Broadland District Council and South Norfolk Council Response to Examining Authority's Written Questions (ExQ1)

Deadline D2 (14th September 2021) (Extended 23rd September 2021)

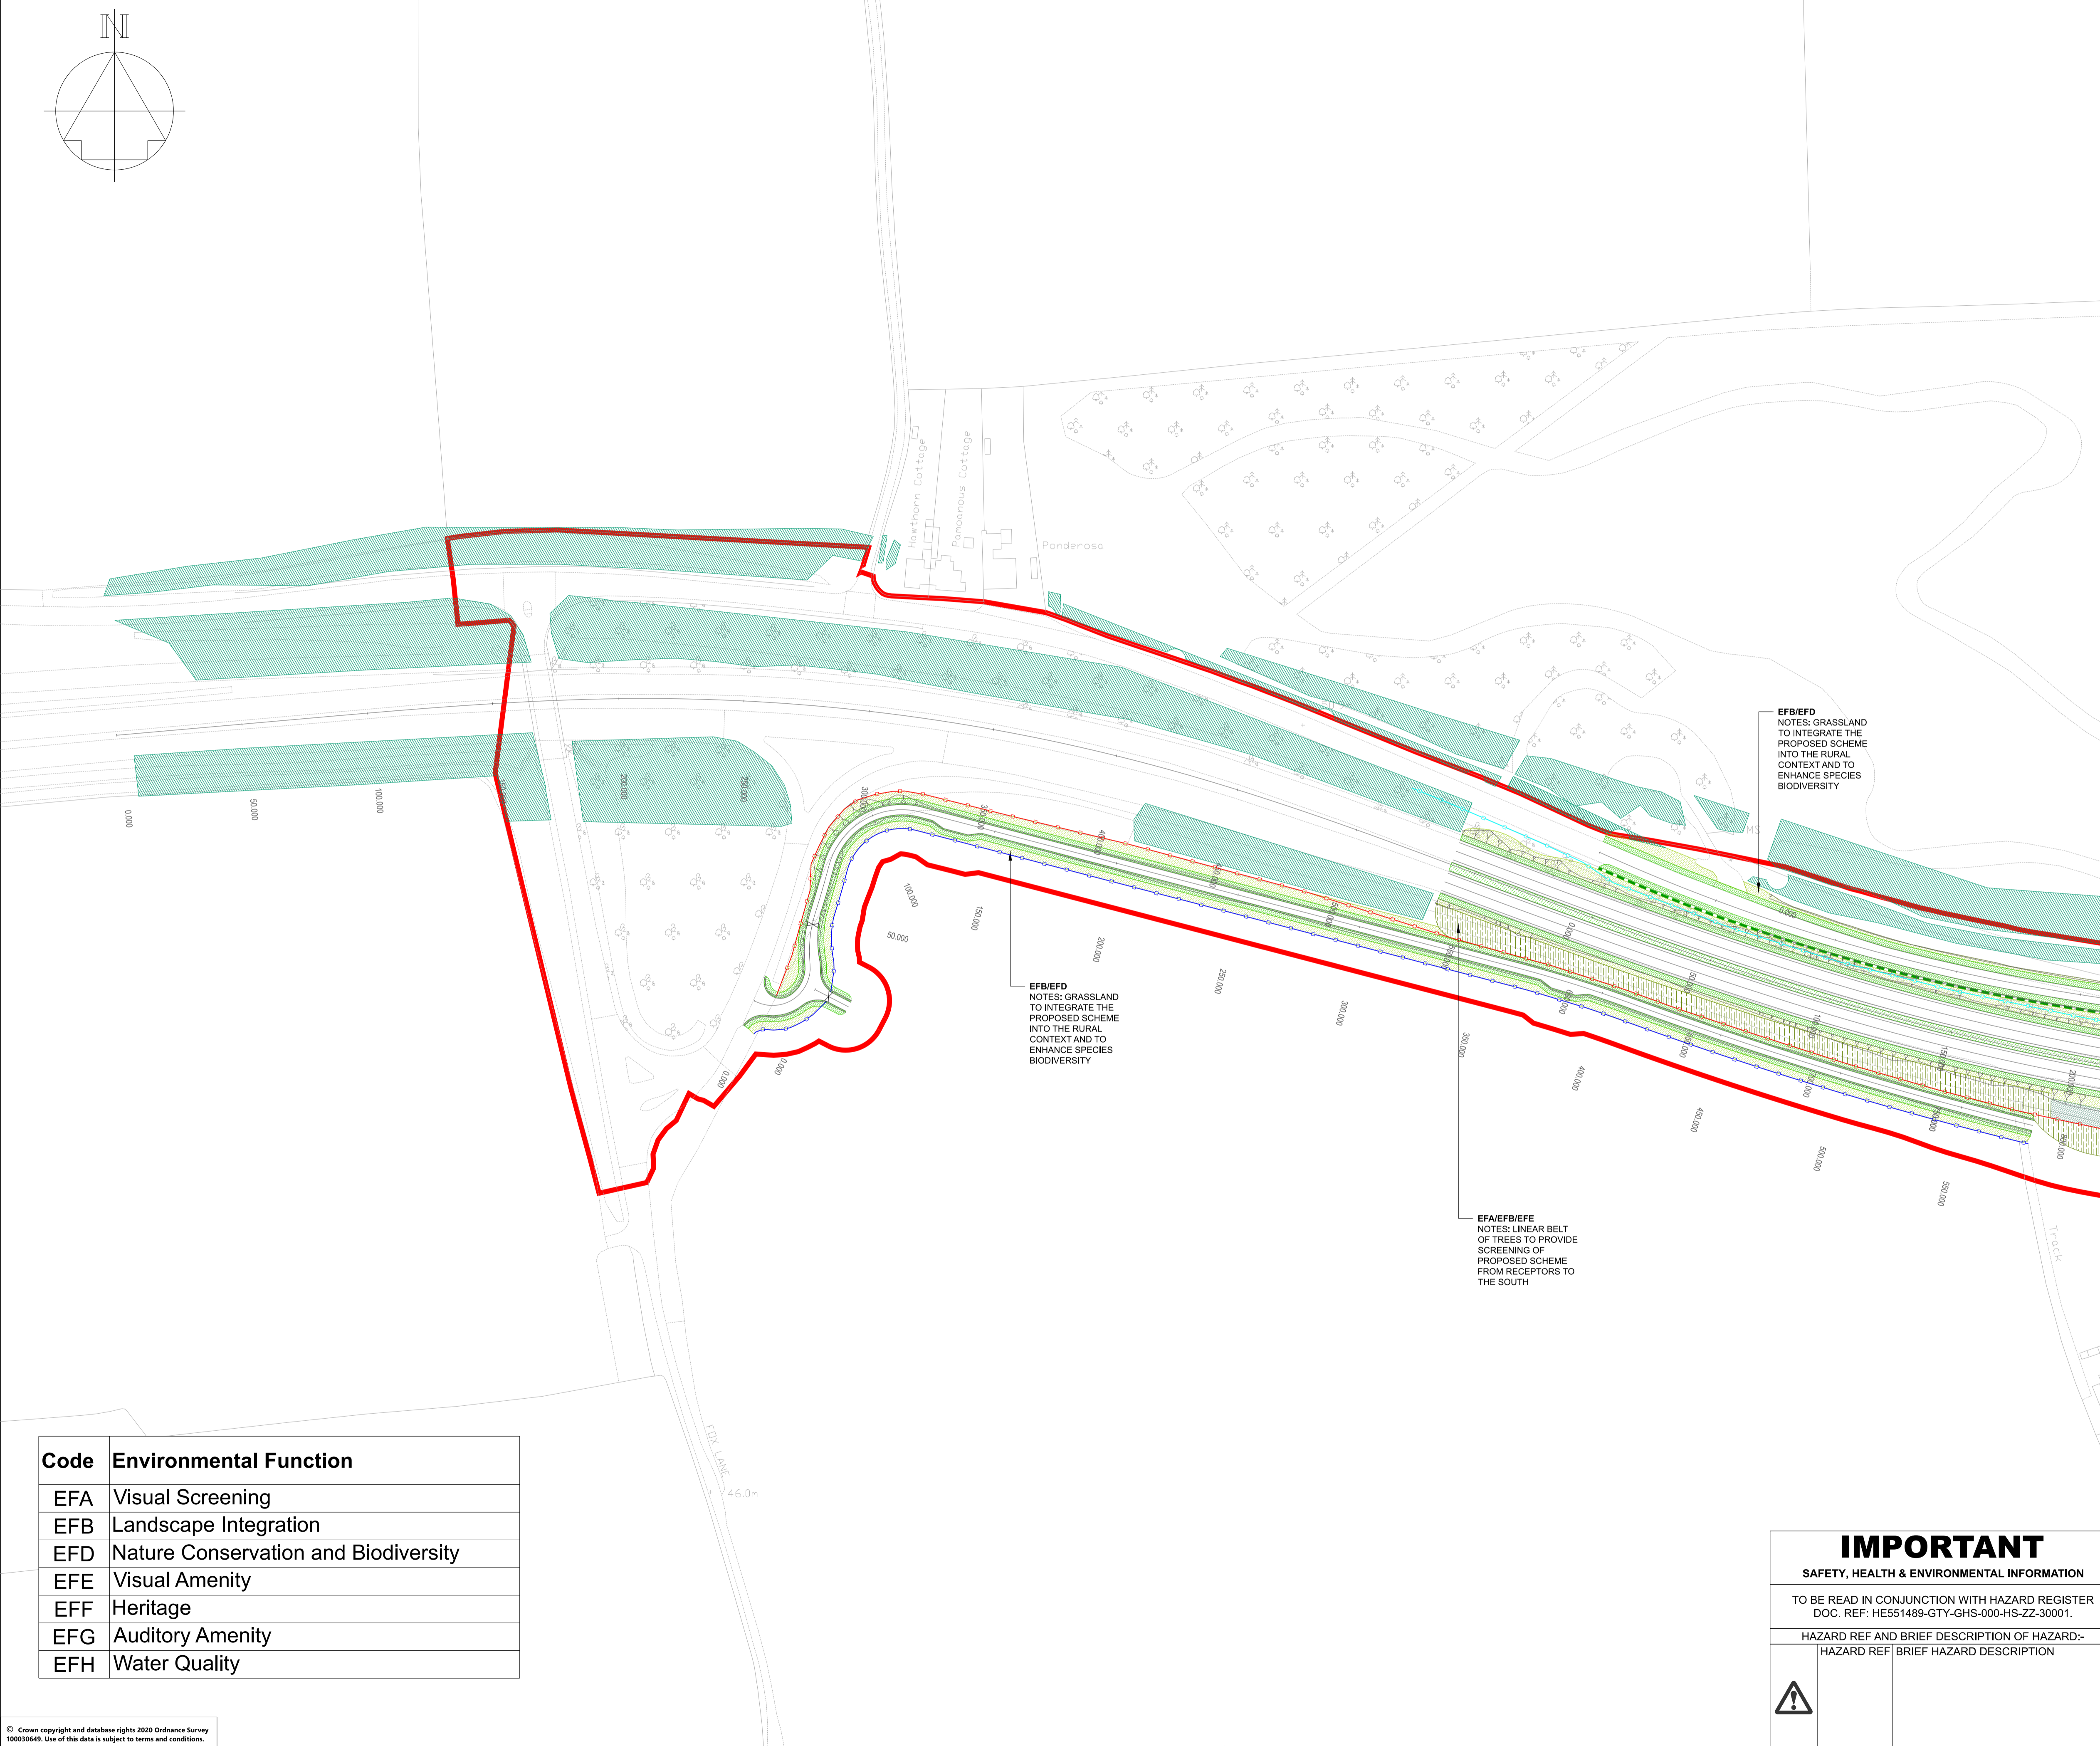
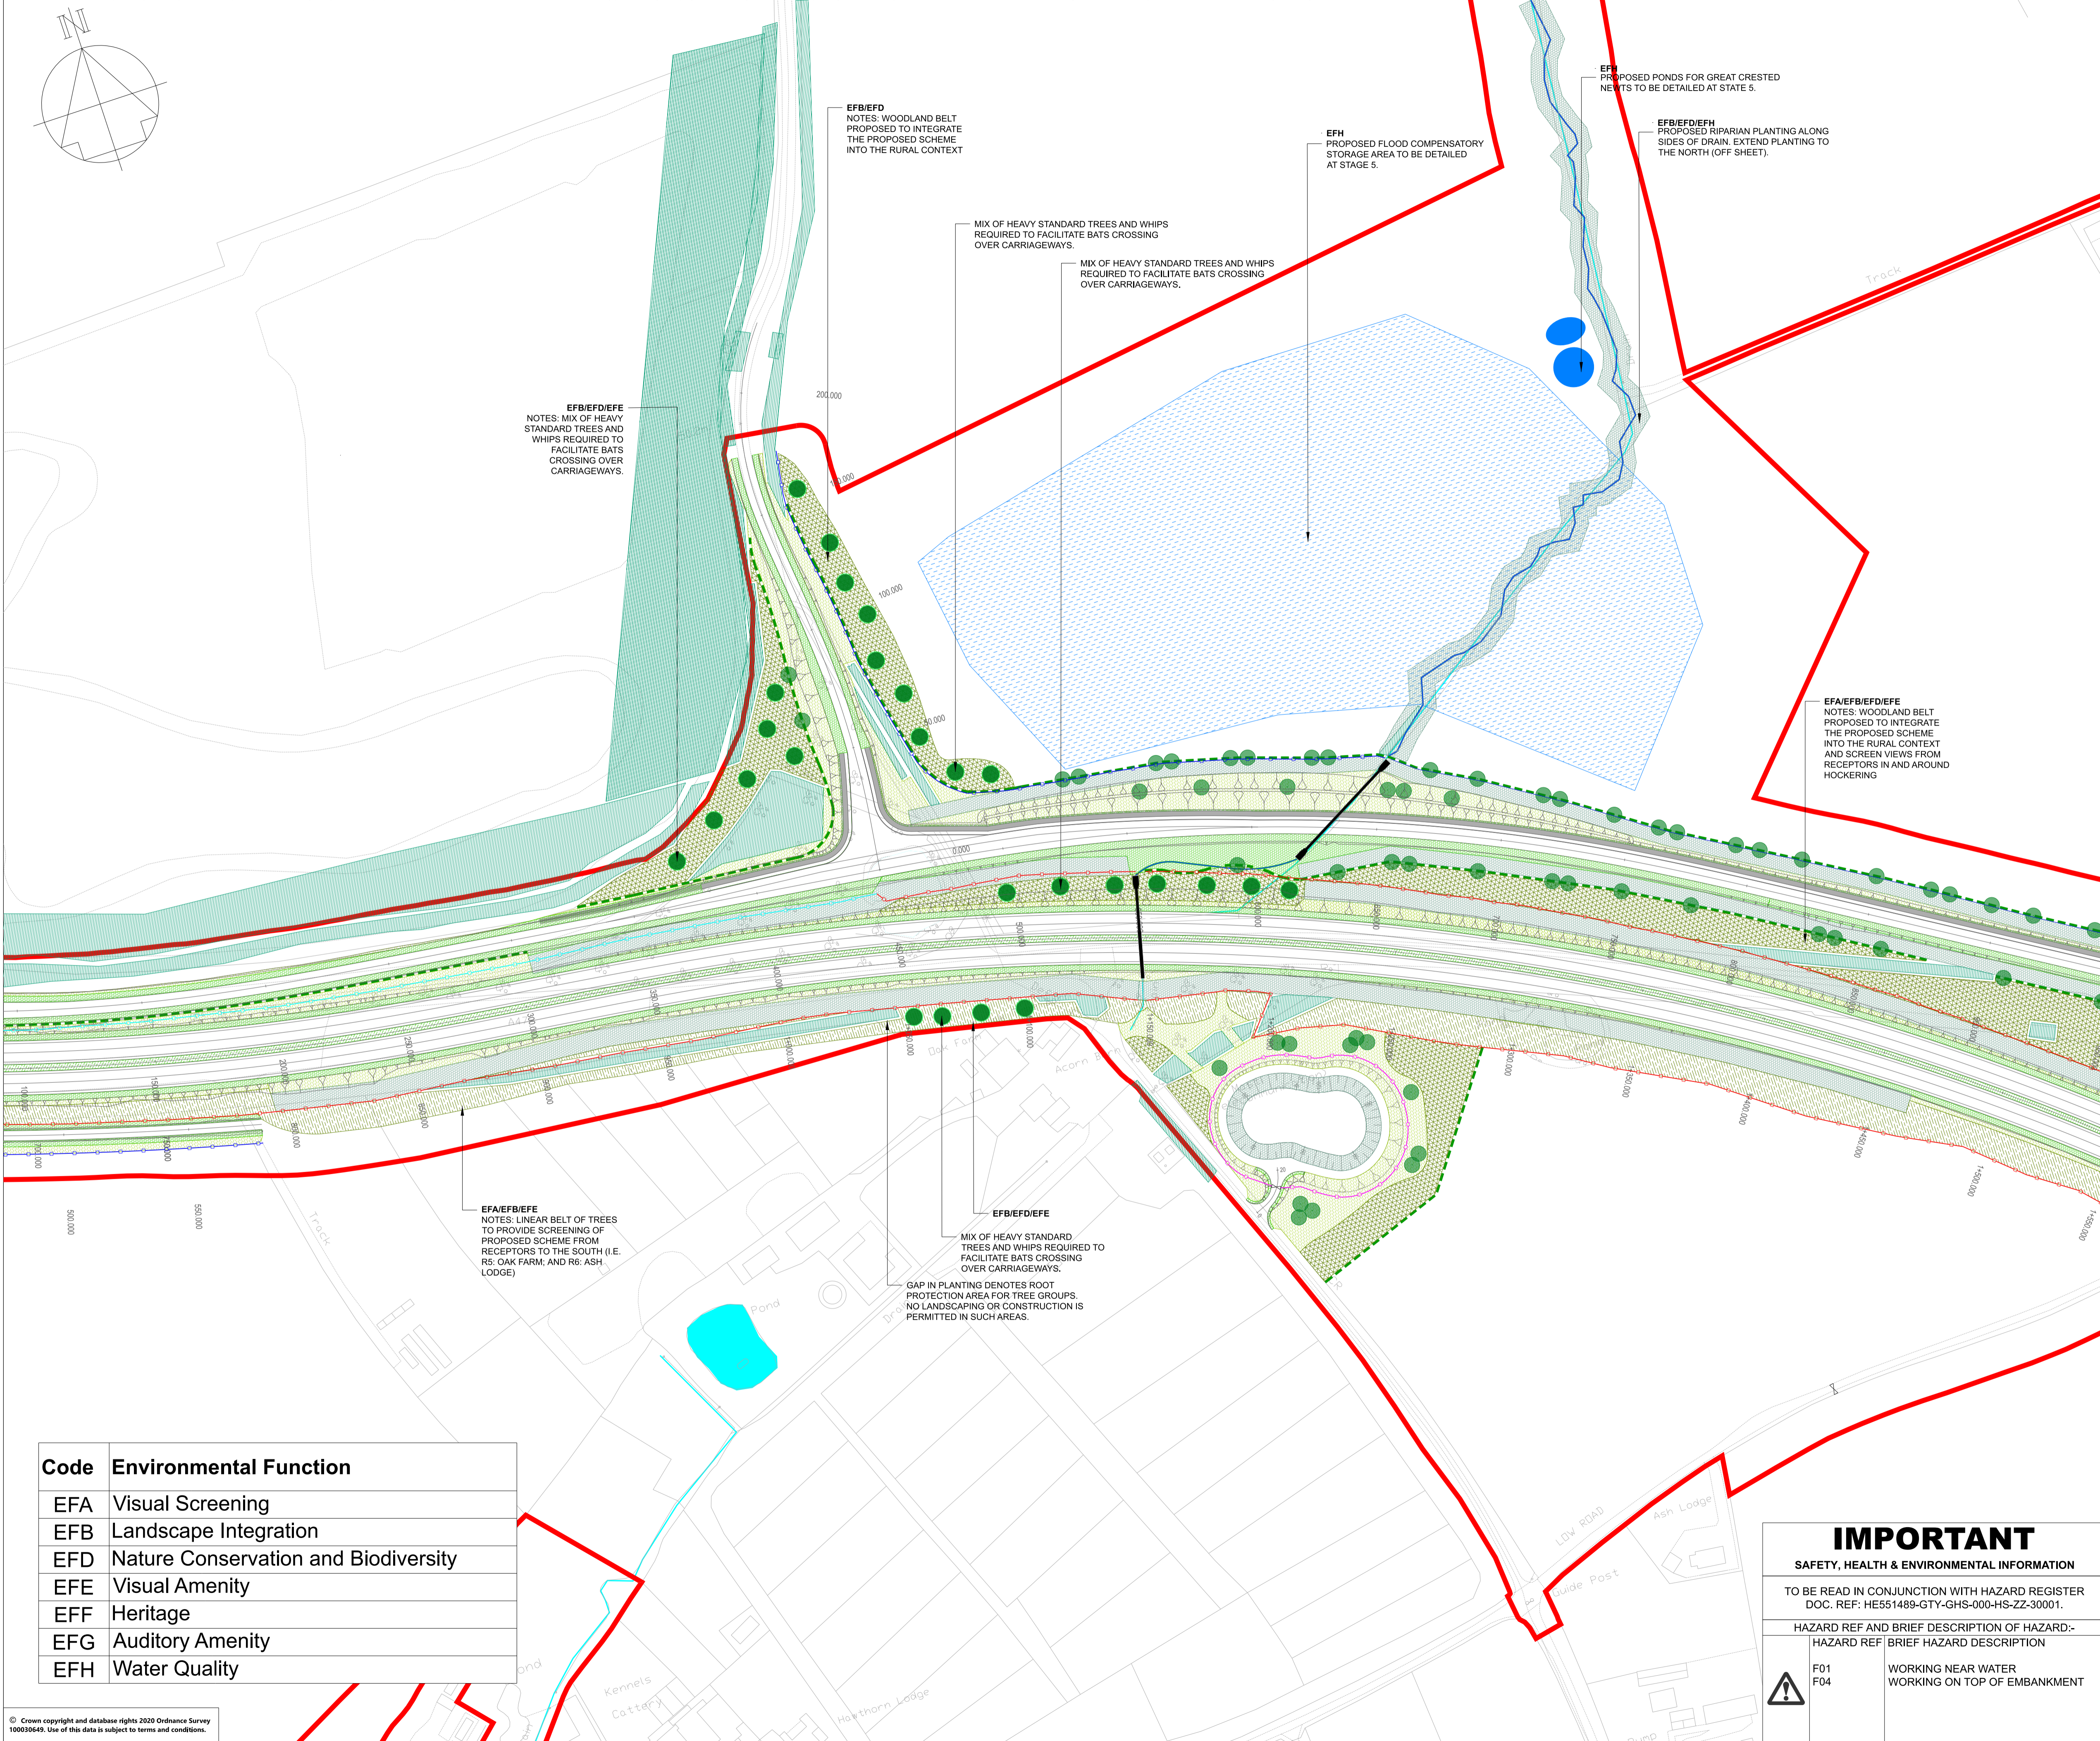
10.0.2	Are the parties satisfied with the Environmental Masterplan [APP-138] and the indicative proposals shown for the Proposed Development?	<p>These remarks were offered previously, but do not appear to have been considered:</p> <ul style="list-style-type: none"> • Reservations about the proposed formal approach to planting around the Eastern pedestrian/cycle bridge; this is not an urban area as the annotation suggests. • Will it be possible to view St Peter's Church Easton from the pedestrian/cycle crossing and/or its approach(es)? If not, is this desirable/possible? • What is the function of the spur of former Church Lane to the north of the proposed Easton pedestrian/cycle bridge? Is this necessary?
